**WEST SUSSEX COUNTY COUNCIL
INFRASTRUCTURE CONSULTATION**

SUBJECT: AL/27/09/DOC - Application for discharge of conditions No's 2, 3, 5, 8, 9, 10 & 11 in relation to AL/23/06

The Homestead, Westergate Street, Westergate, West Sussex

Drg.Title: SURFACE FINISHES

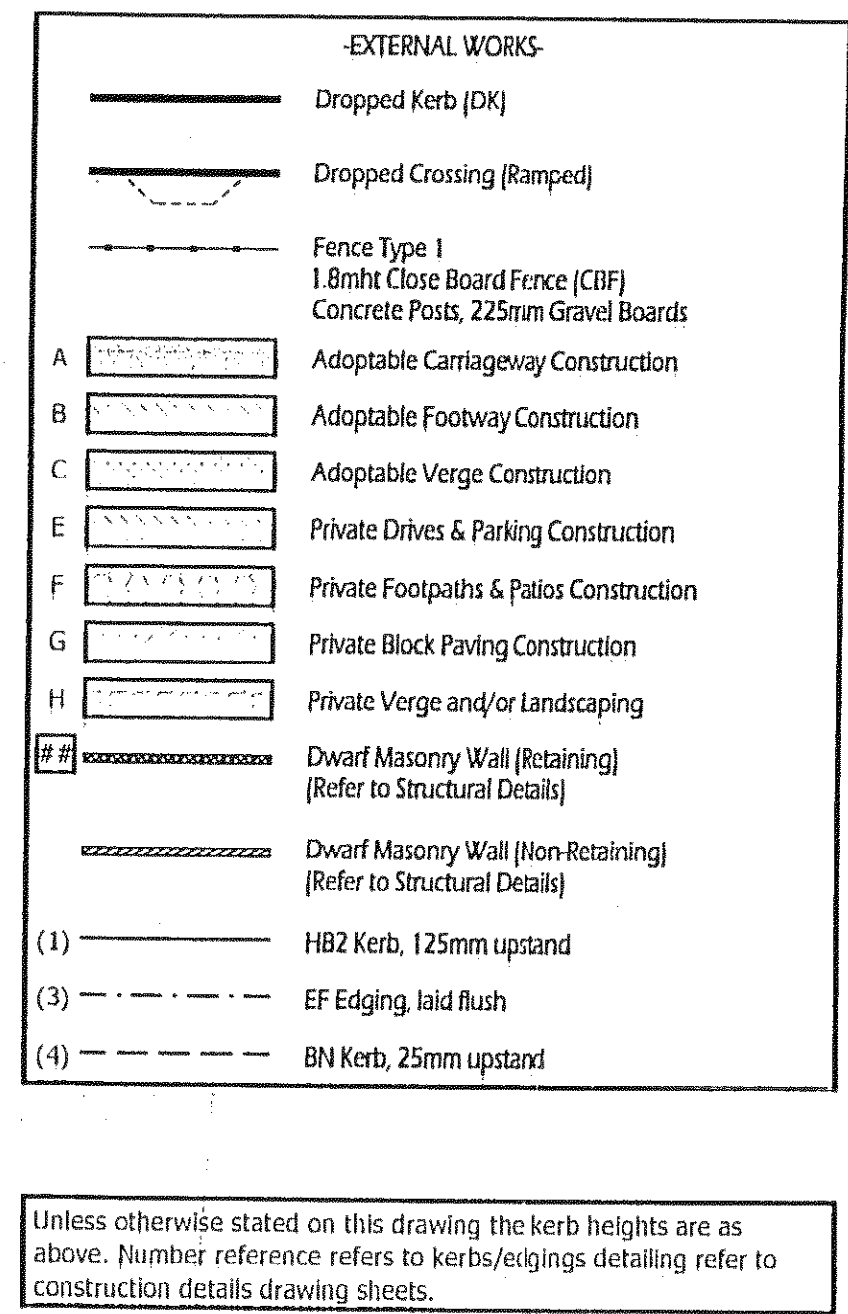
Condition 8 requires the provision of visibility splays of 4.5 by 70metres. It is noted that the Applicant states that the splays have now been provided on site. Could a plan be provided demonstrating that the splays can be provided without encroaching upon 3rd party land? This plan would be sought prior to the condition being discharged.
